KIRKLEES METROPOLITAN COUNCIL INVESTMENT & REGENERATION SERVICE

Reference No:	2021/44/92901/W
Site Address:	Former Midlothian Garage, New Mill Road, Holmfirth, HD9 7LN
Description:	Discharge of conditions 5 (junction works) and 8 (internal estate roads) of previous outline permission 2015/93824 for erection of 56 dwellings and care home with associated car parking
Recommending Officer:	Nick Hirst

DECISION – Discharge of Conditions – Refuse

Report Dated: 23/08/2024.

CHAINAGE	0.000	9.149
EXISTING GROUND LEVEL	183.110	183.195
ALIGNMENT LEVEL	183.110	182.703
VERTICAL ALIGNMENT	G= -4.449% 1: -22.5	
HORIZONTAL ALIGNMENT	R= 6.000

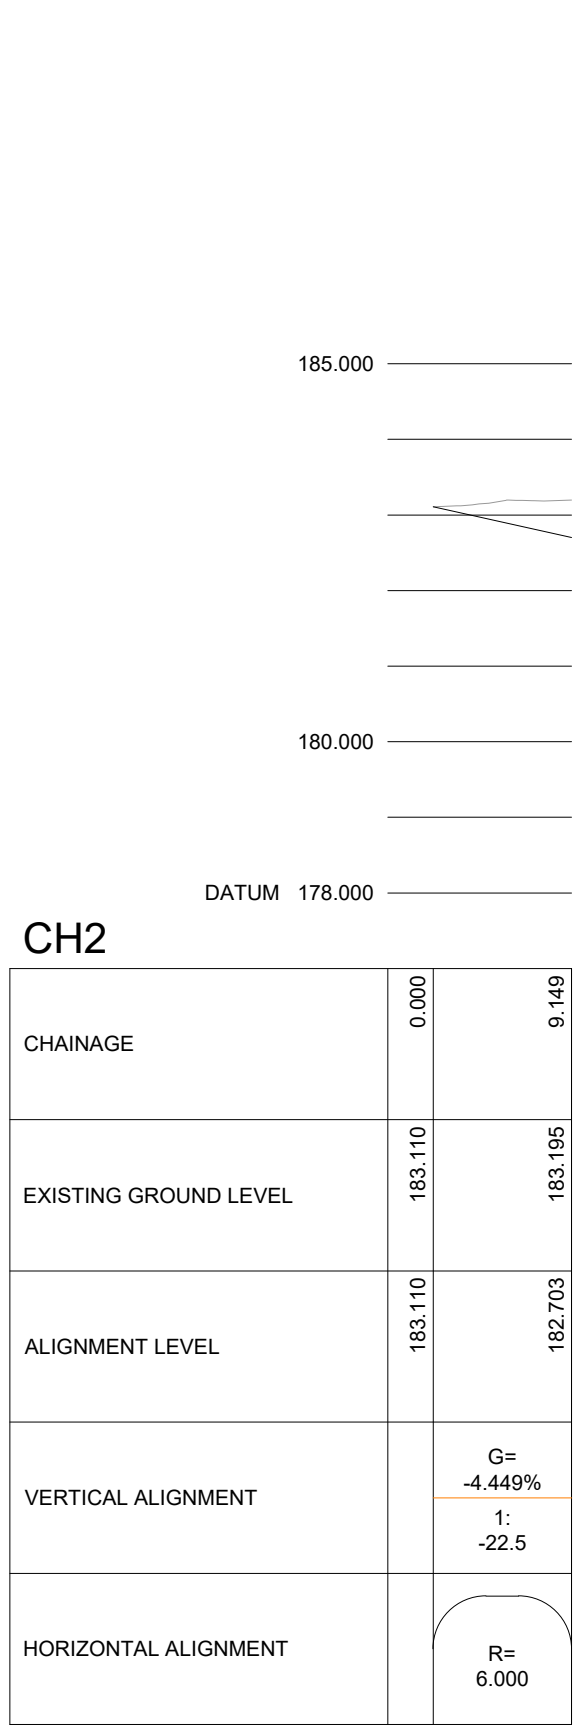
- There is a lack of cross-sectional information, particularly relating to highway retaining features;
- The drainage proposals are not satisfactory, including unacceptable gully locations and road levels/contours;
